Report of the Head of Development Management and Building Control Committee Report Part 2 – Application Report

57533/APP/2023/3146

Site Address: **140 Fairholme Crescent**

Proposal: **Creation of an extra bedroom to a 6 unit HMO (Class C4) to create 7 bedrooms (Sui Generis).**

PROPOSED FLOOR PLANS

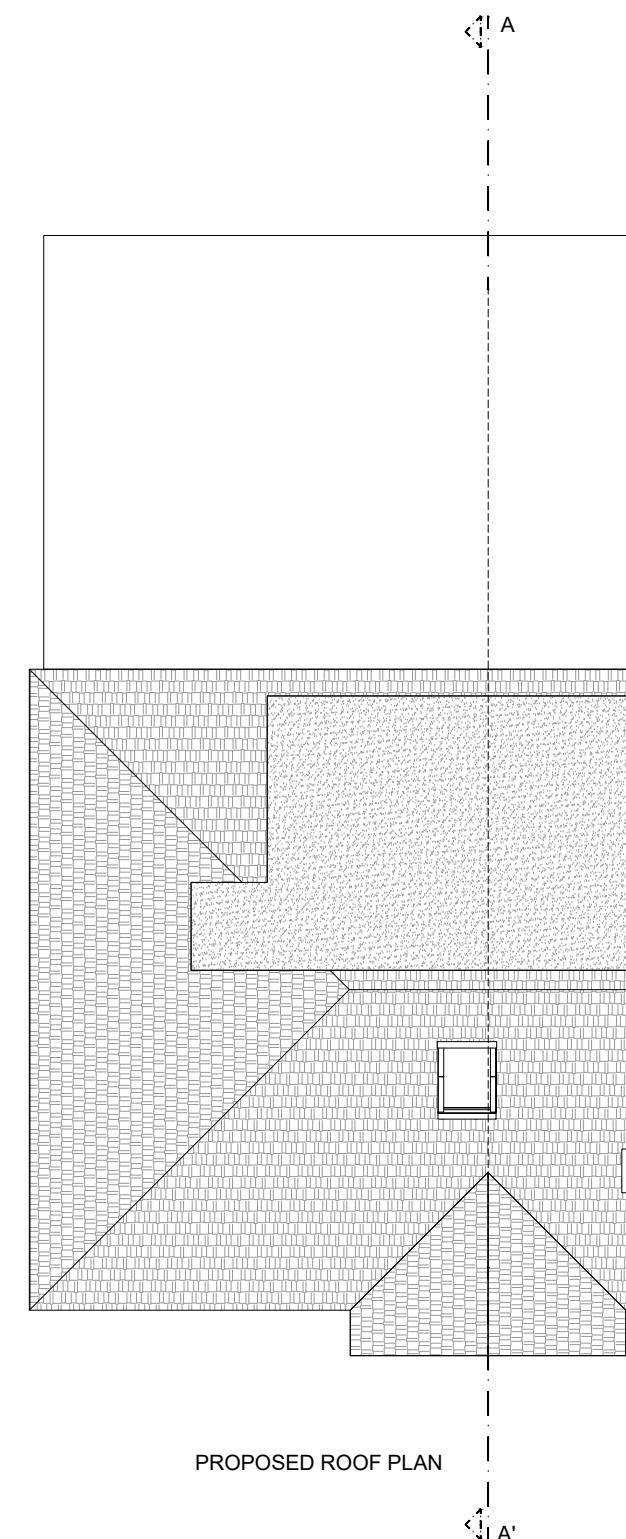
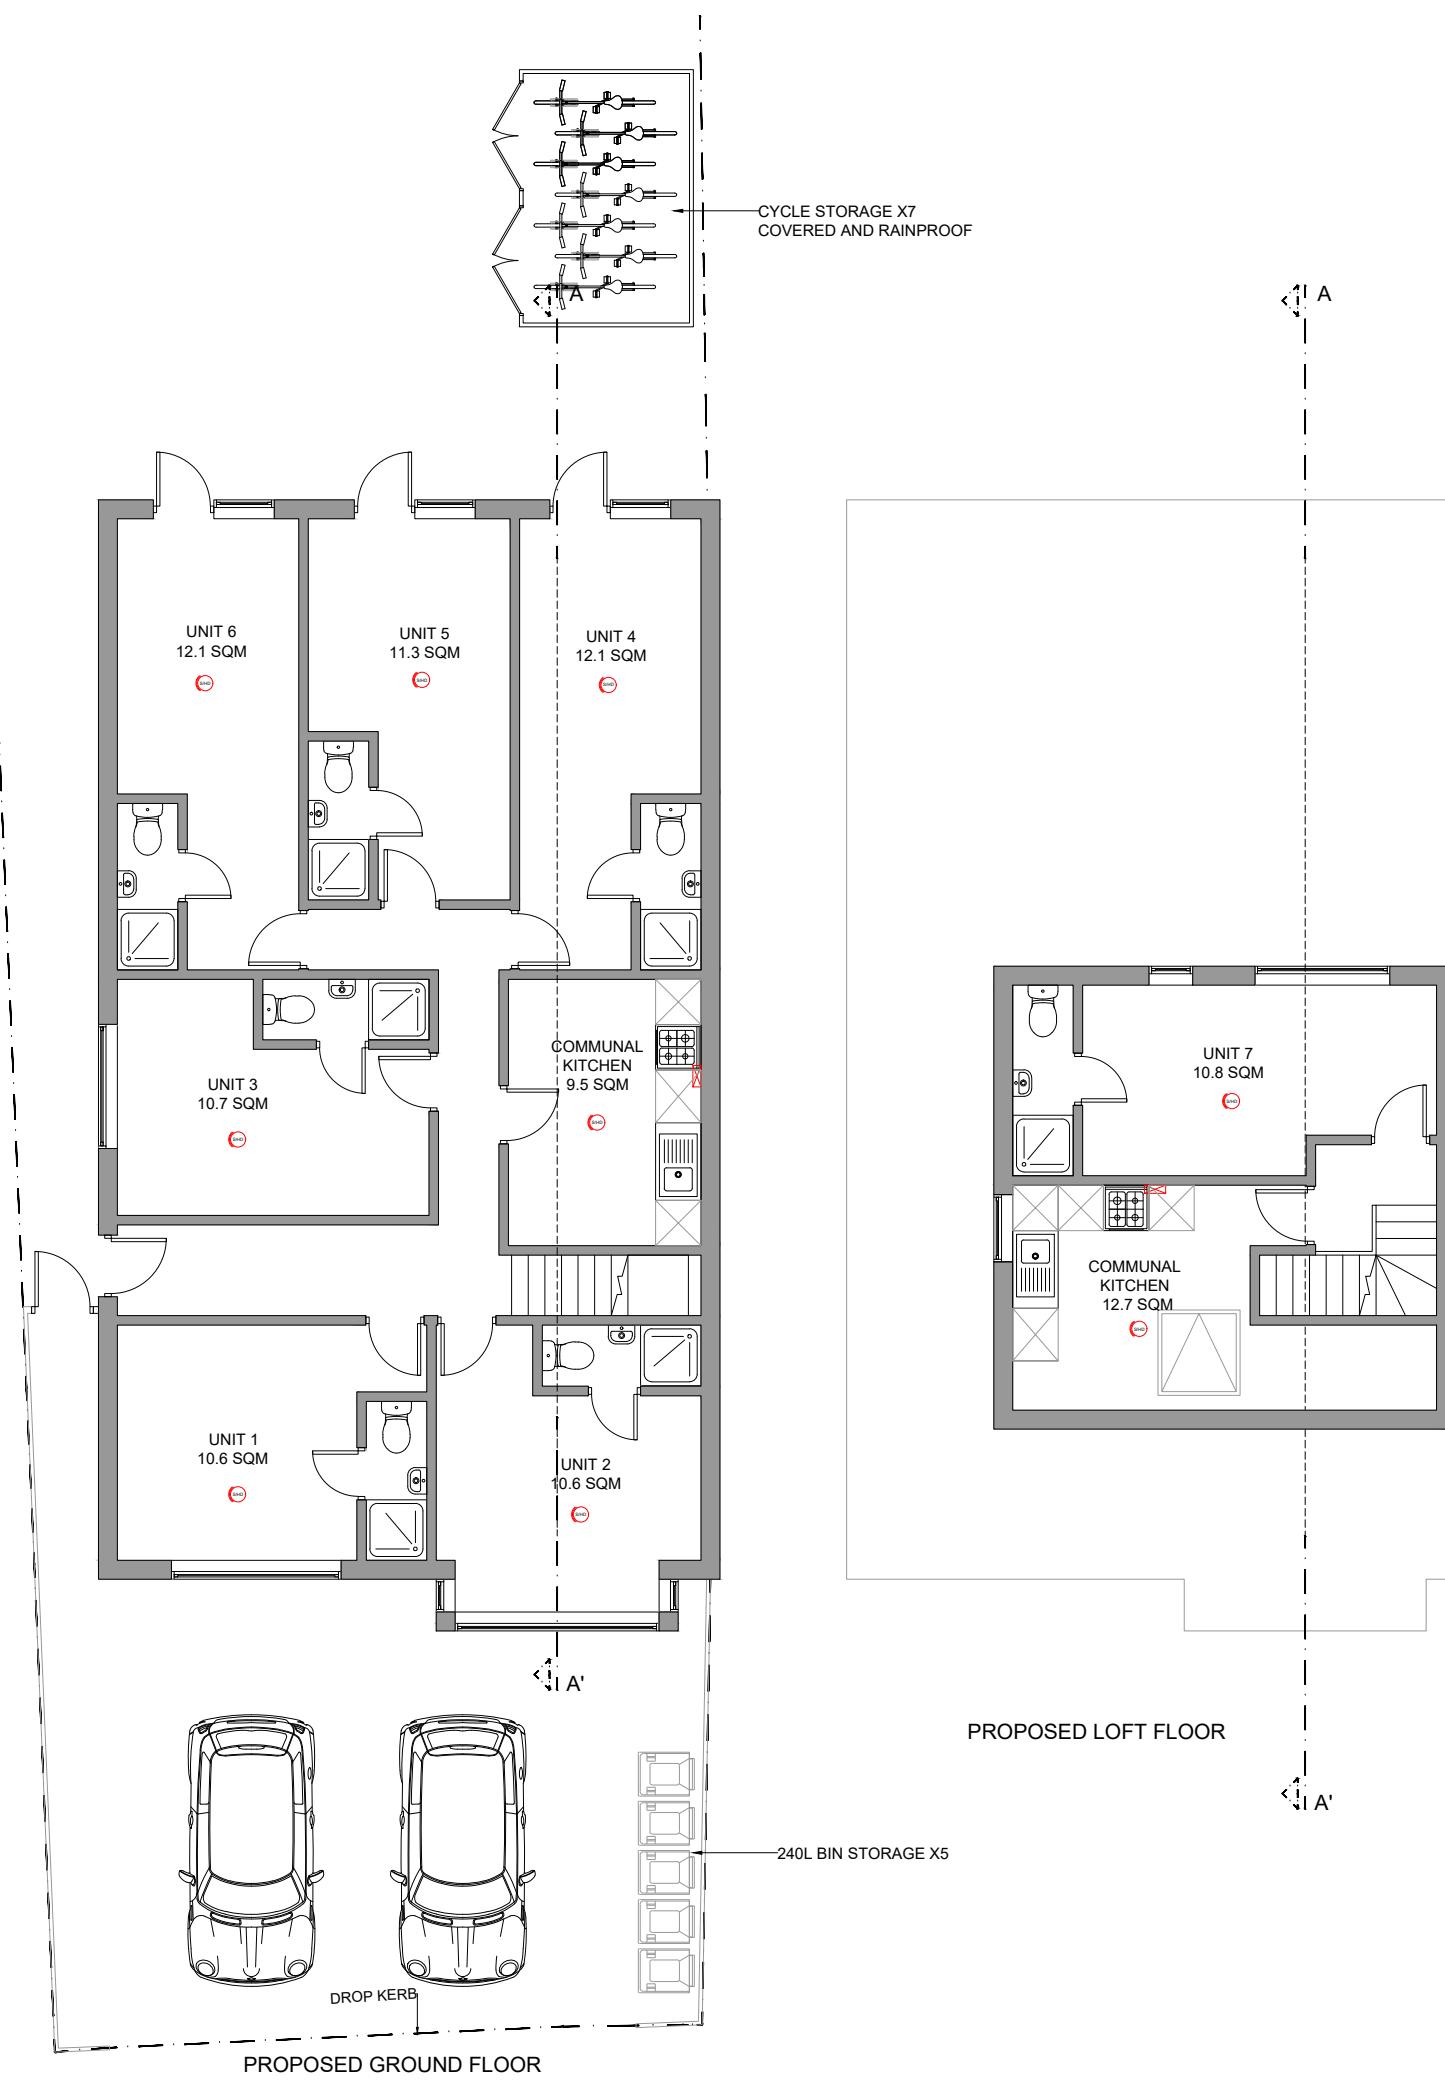
- 7.34 The proposed HMO comprises 7 bedrooms, the GIA of the internal accommodation within the building is set out below:
- 7.35 Bedroom 1: 10.6m² (single bedspace)
Bedroom 2: 10.6m² (single bedspace)
Bedroom 3: 10.7m² (single bedspace)
Bedroom 4: 12.1m² (double bedspace)
Bedroom 5: 11.3m² (single bedspace)
Bedroom 6: 12.1m² (double bedspace)
Bedroom 7: 10.8m² (single bedspace)
Communal Kitchen: 9.5m²
Communal Kitchen: 12.7m²

- 7.37 One additional room would be added at first floor level. The resident of the room would have windows providing access to natural light and outlook, as well as access to communal kitchens and an en-suite (providing sanitary facilities). The resident is considered to be provided with an acceptable level of living accommodation.

PROPOSED SITE PLAN

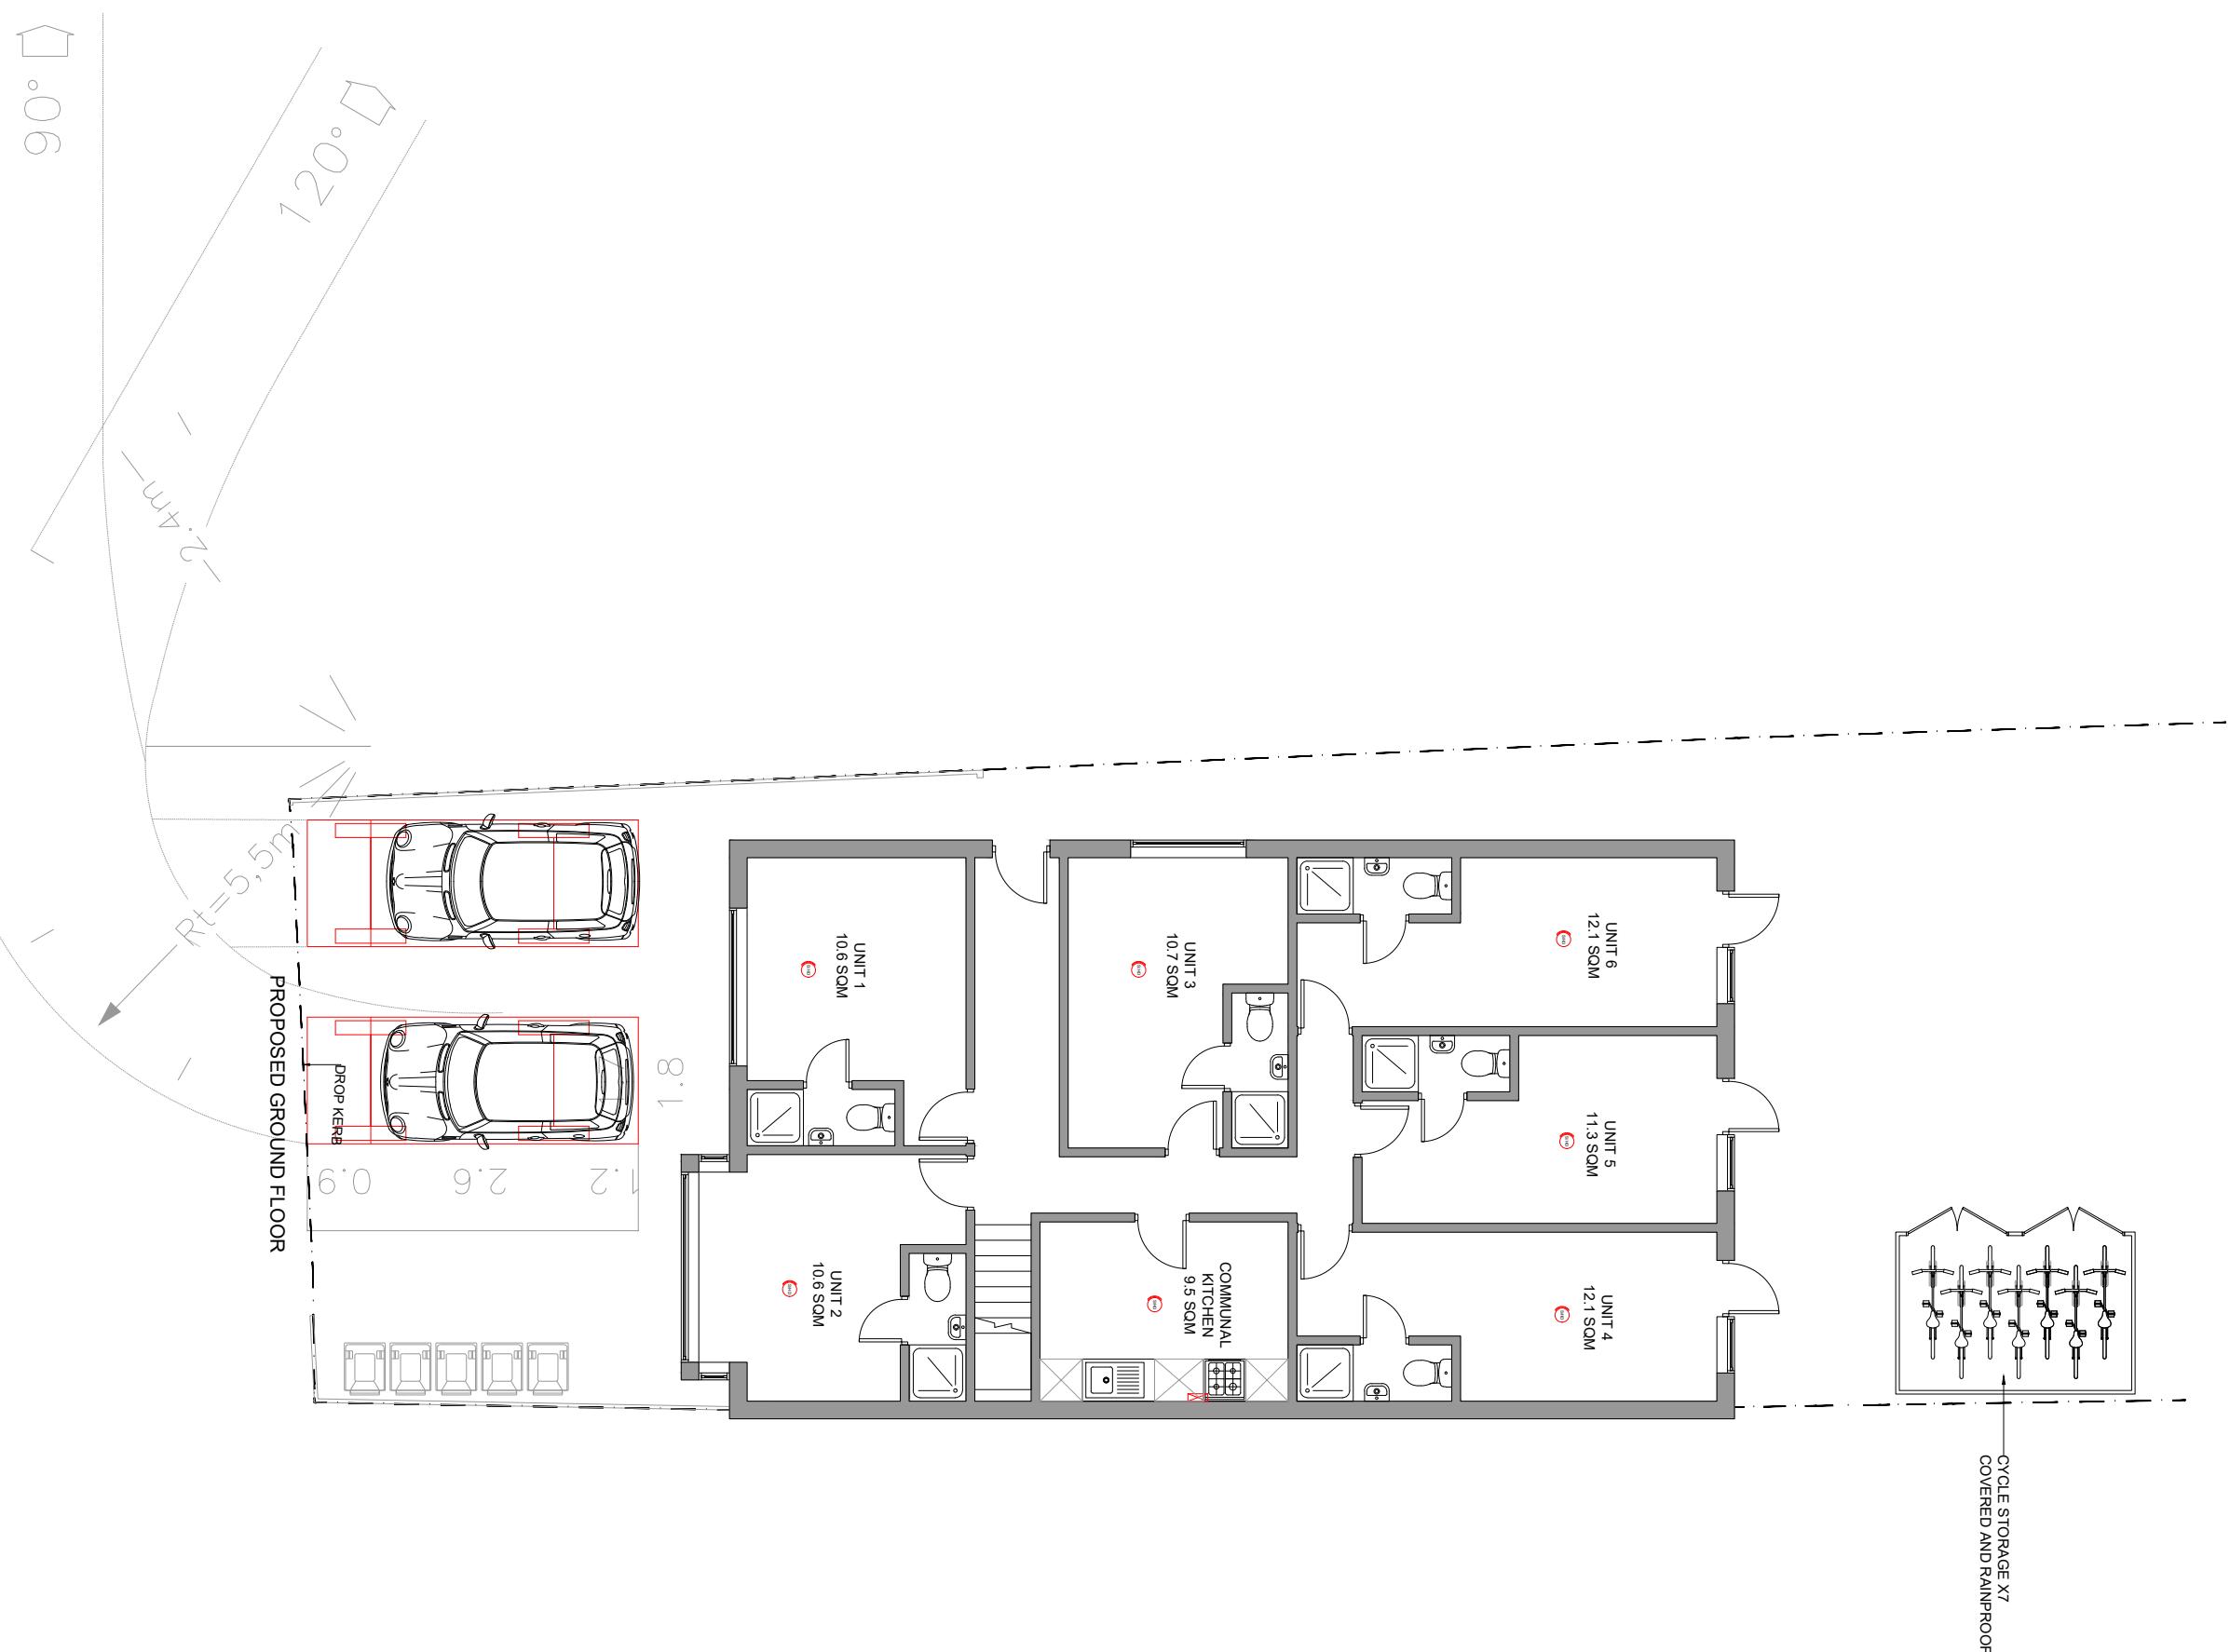
- 7.25 At present two parking spaces, exist at the site serving 6 occupants. The parking spaces are accessed via an existing crossover and the site's parking forecourt is open. The two parking spaces would be retained at the site to serve 7 occupants, and the parking forecourt would remain open as existing. As the sites parking situation would be unaltered it is considered unreasonable to recommend a condition be added requiring that the drop kerb be extended at the front of the site.

- 7.32 The submitted plans show that waste storage facilities would be sited next to the road, like other dwellings in the area. The location of the facilities is considered to be acceptable. Nevertheless, the London borough of Hillingdon does not operate a bin collection service. If planning permission is granted, a condition is recommended requiring full details of the design, location and sizes of all refuse and recycling storage facilities to be used at HMO. The applicant would be required to provide waste storage of an appropriate size for the service.
